Re: Permit #2212-162
Rader SFR Addition and Remodel
7310 86th Ave SE
Intake Comment Response Letter

Regarding the combined intake comments dated 1/4/23 for the remodel/addition permit application listed above, we would like to provide the following corrections and locations on the drawings where they can be found (responses are bulleted and italicized below summarized comment):

STORMWATER CALCULATIONS

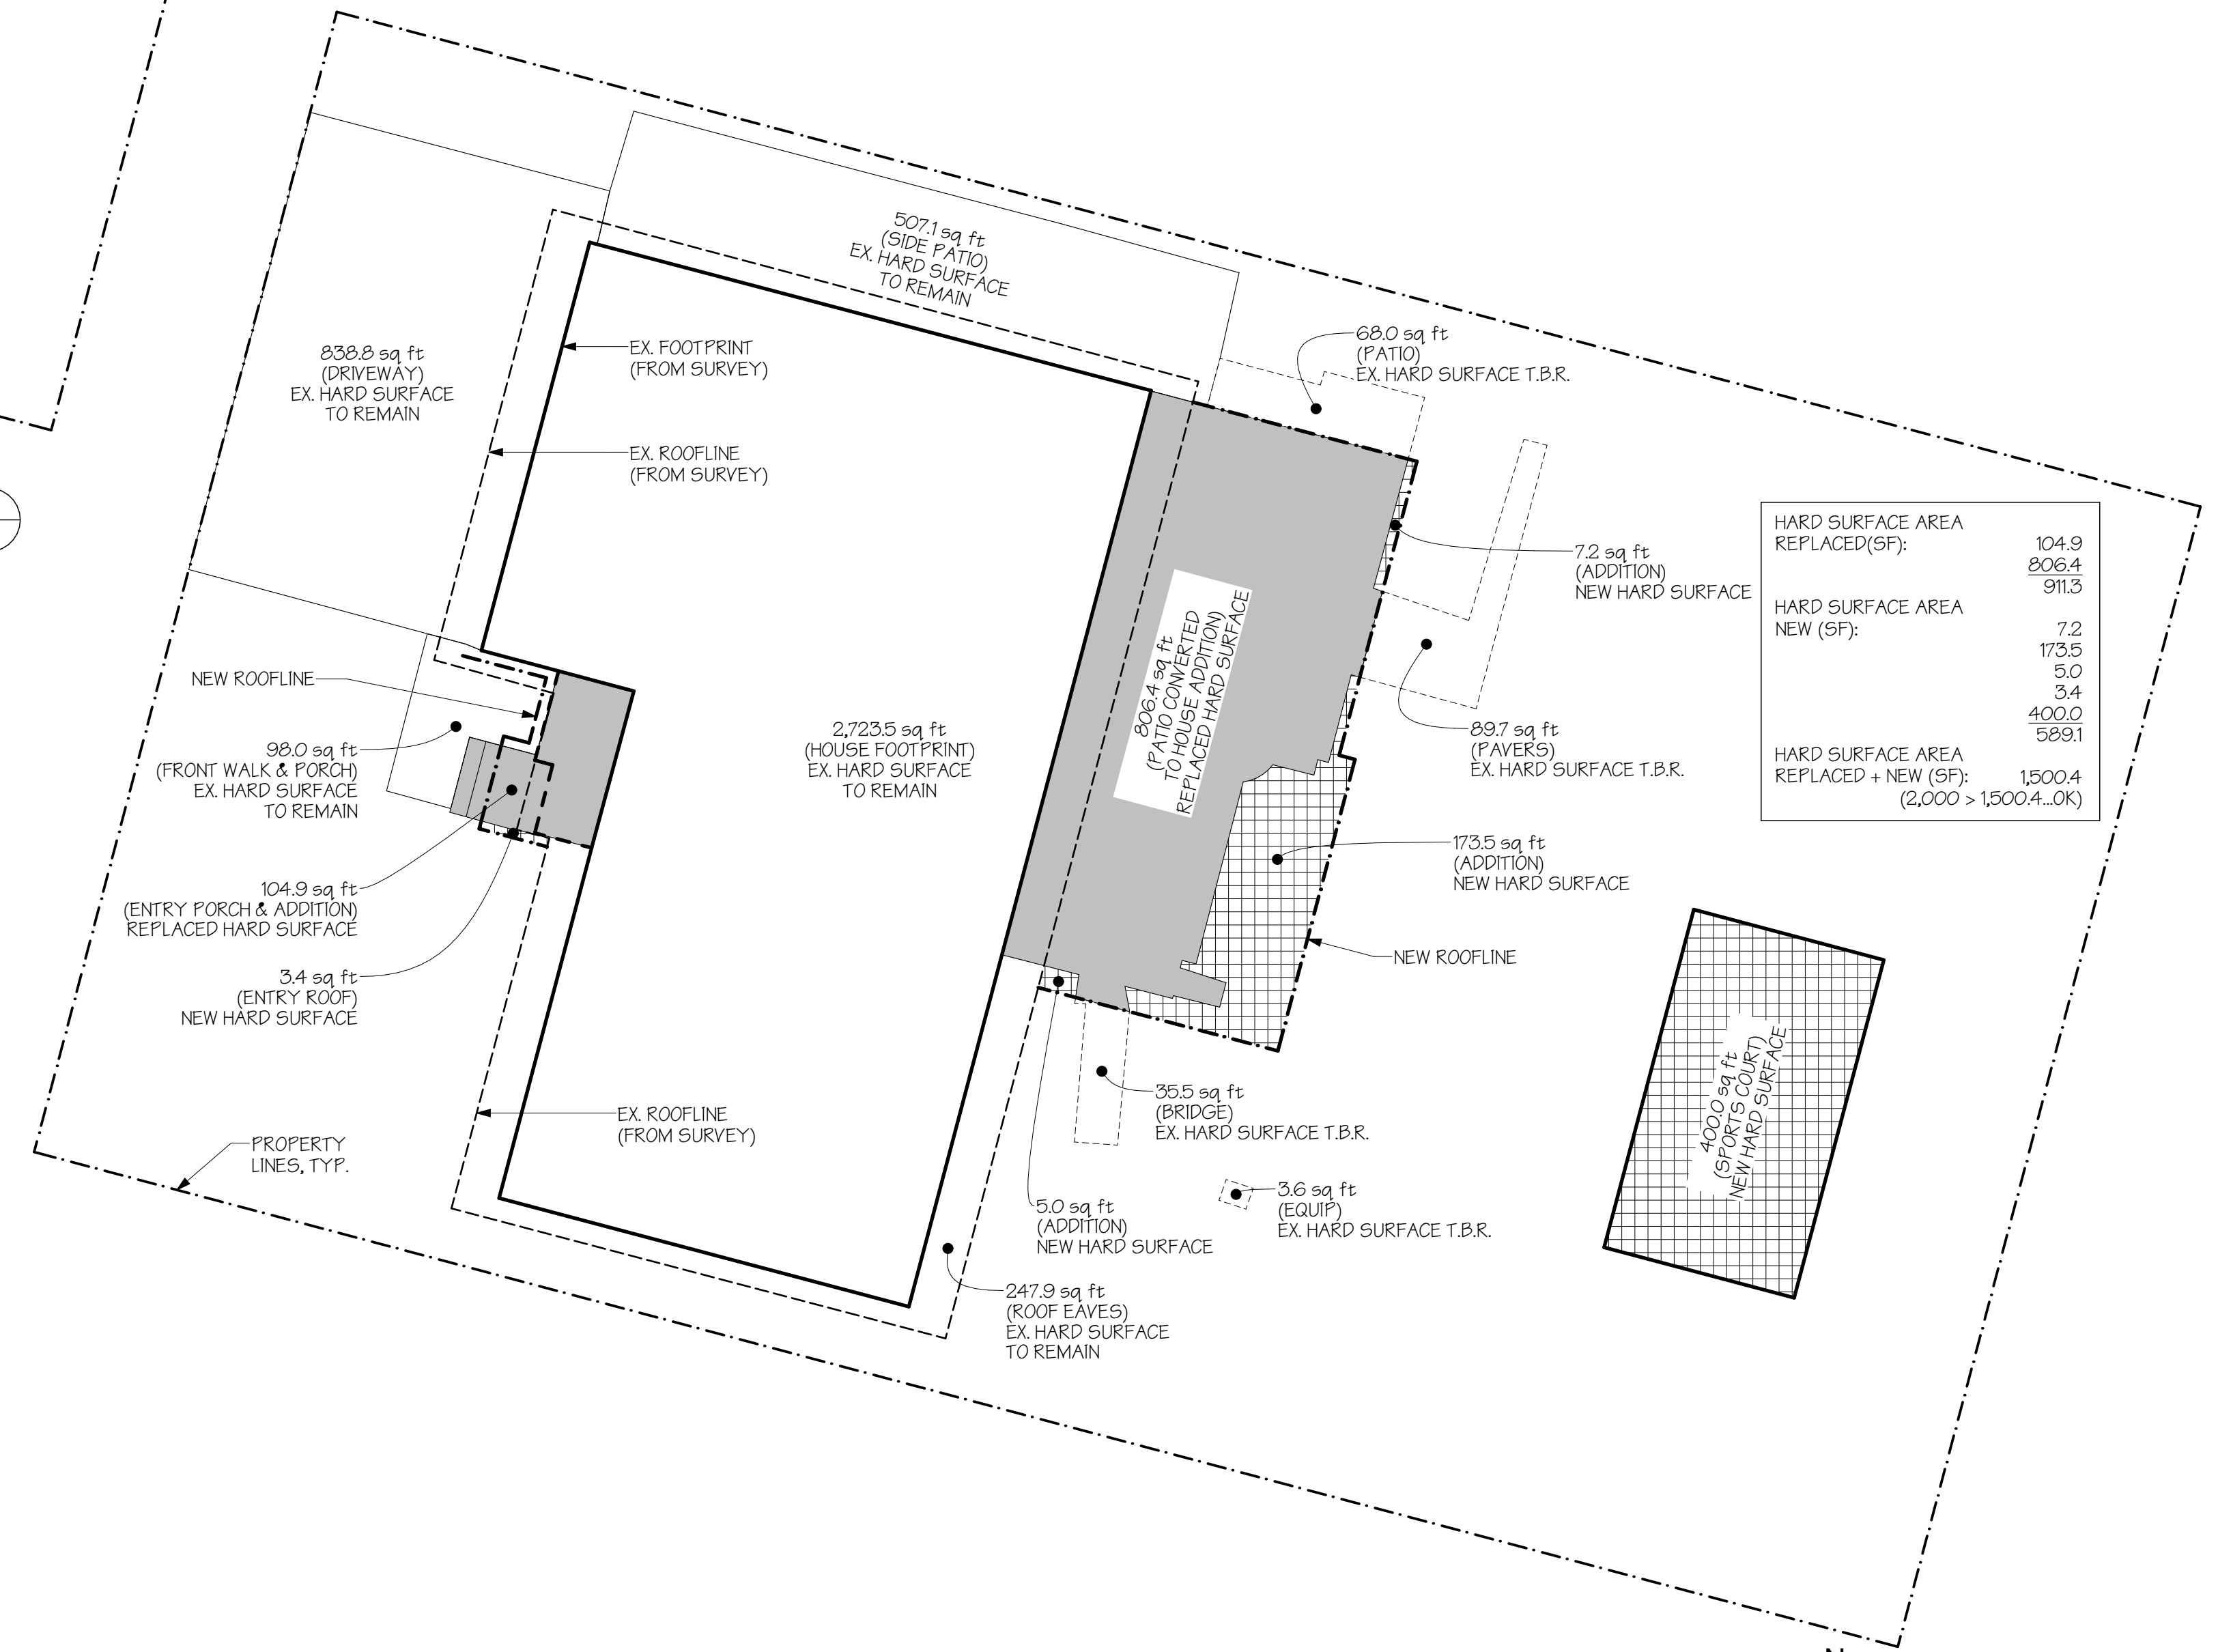
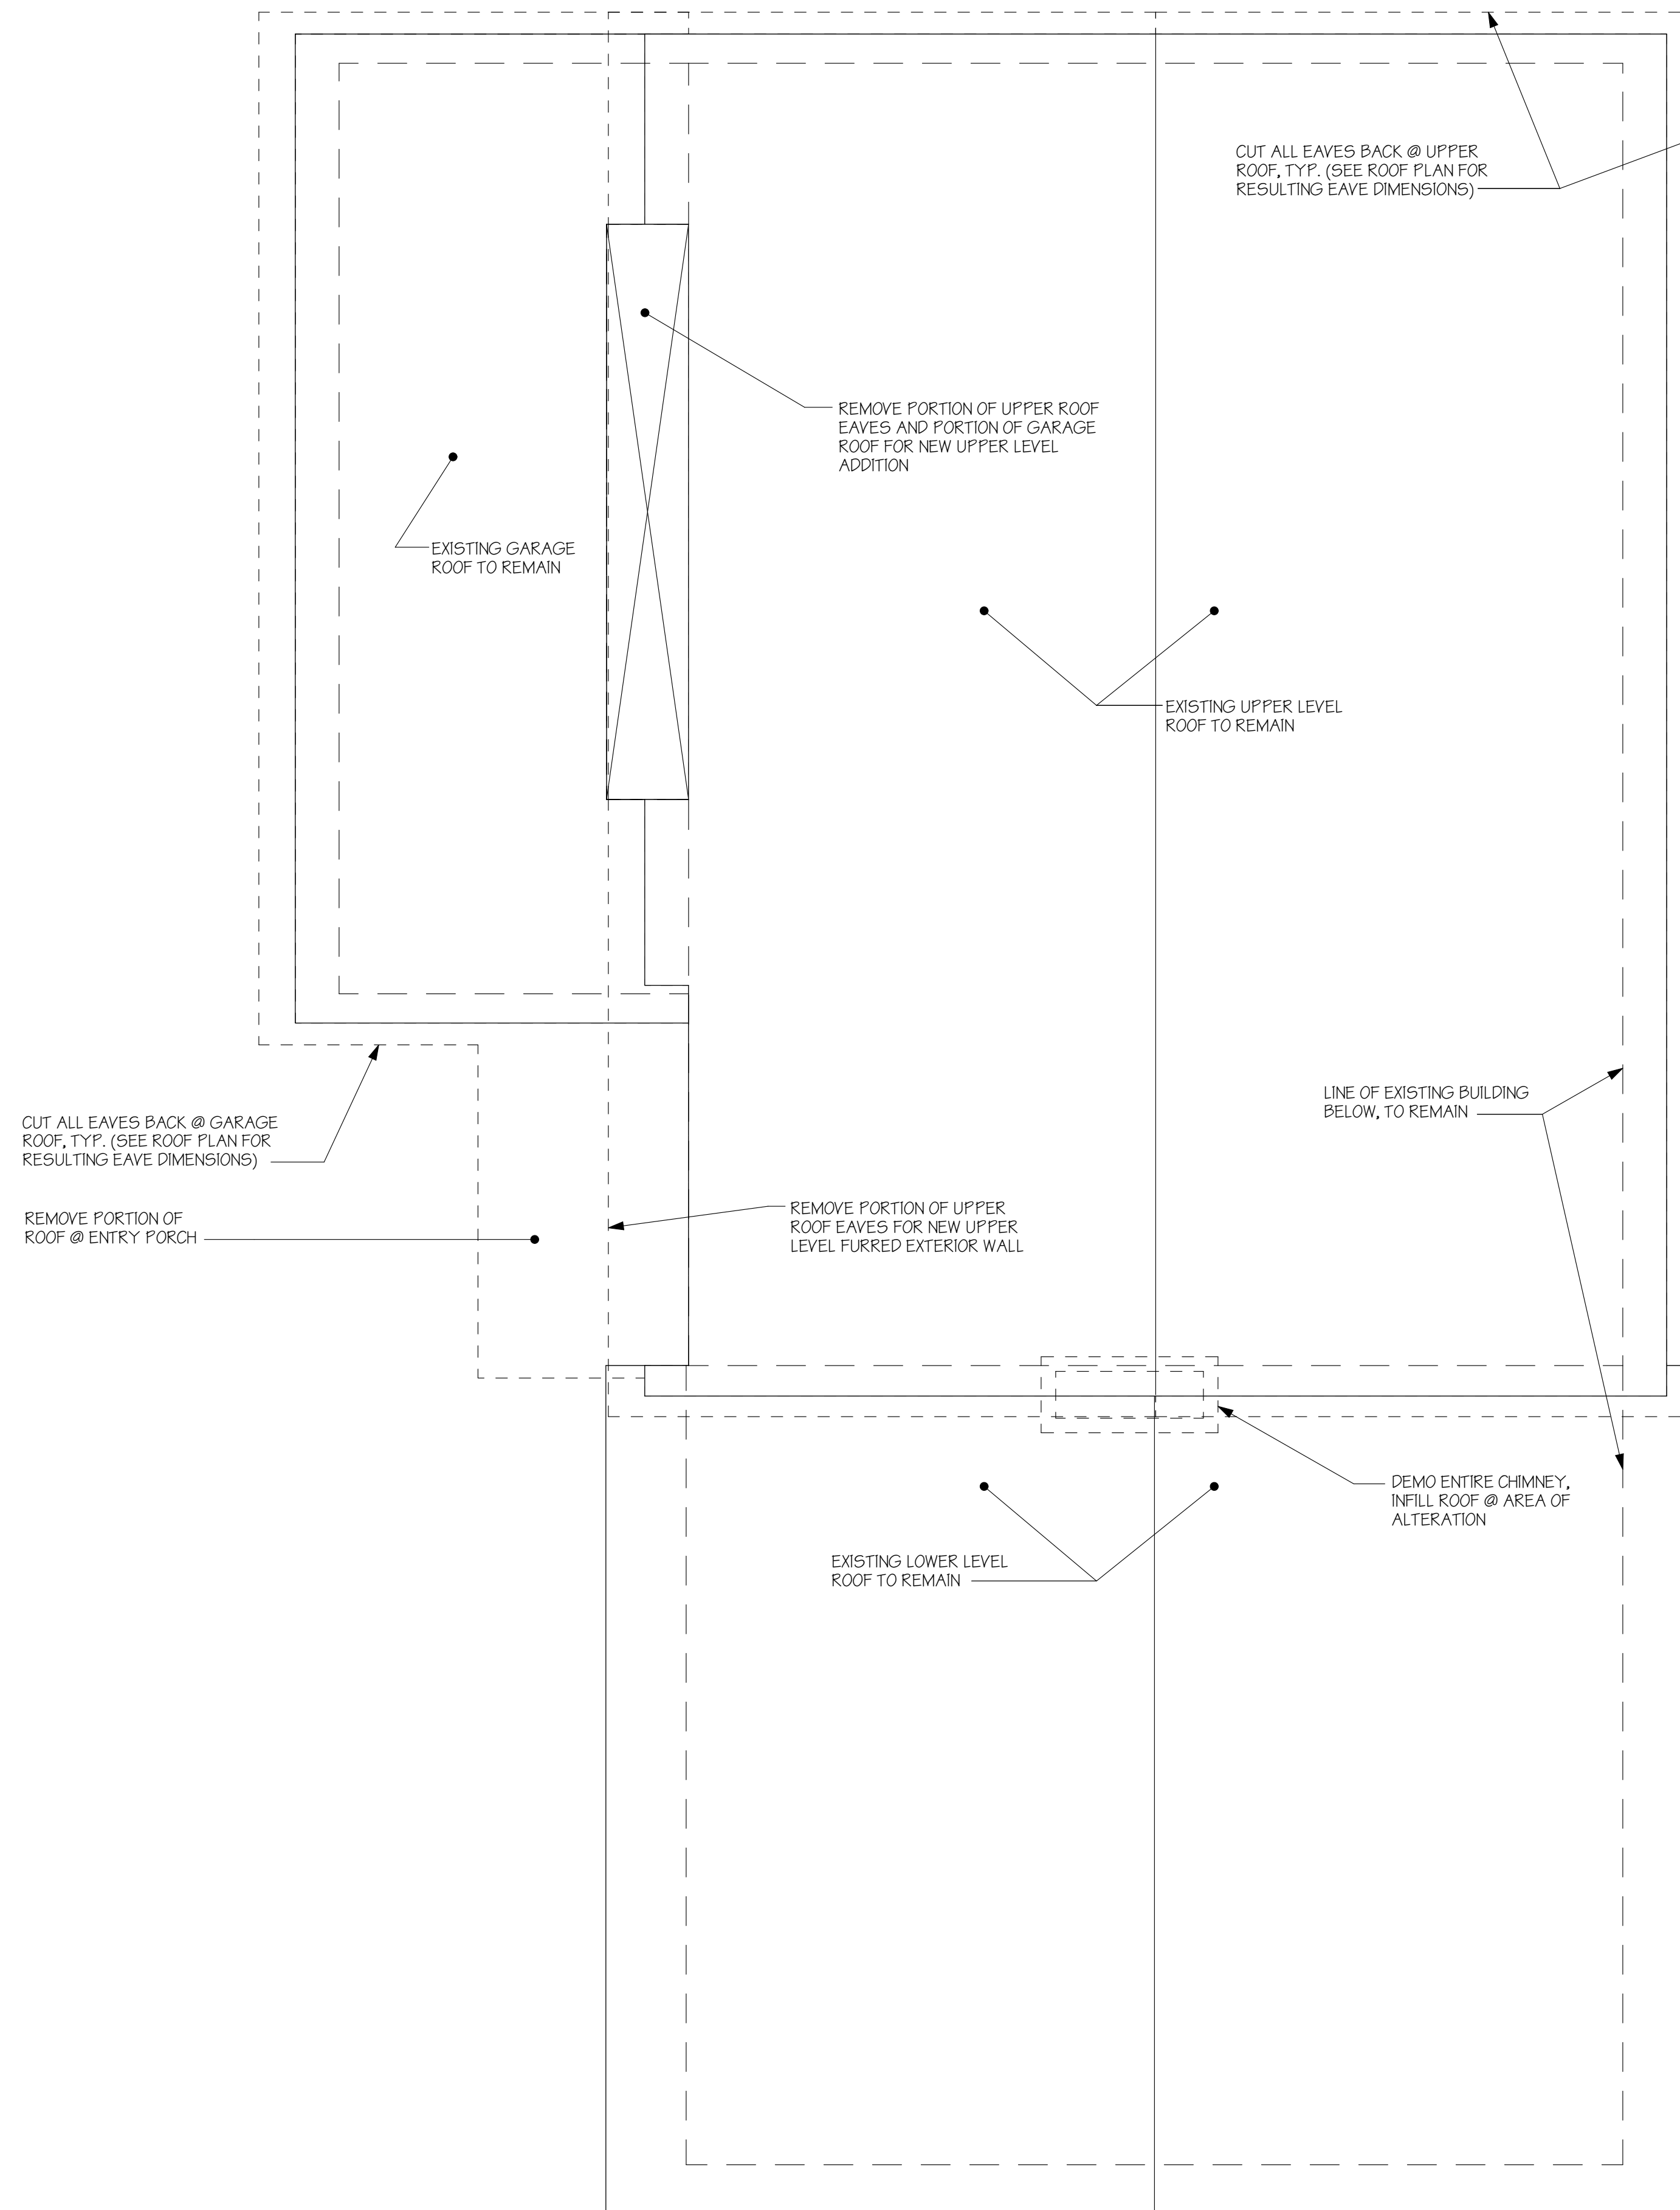
1. Site Plan calculating removal and addition of impervious area (net increase of 500+ sf requires full drainage report)
 - *See new sheet 03. Impervious calculations shown on site plan; net increase of impervious surface area is 392.3 sf (<500 sf).*

2. Site Plan calculating new plus replaced hard surface (new plus replaced of 2,000+ sf requires full drainage report)
 - *See new sheet 03. Hard surface calculations shown on site plan; new + replaced hard surface area is 1,500.4 sf (<2,000 sf).*
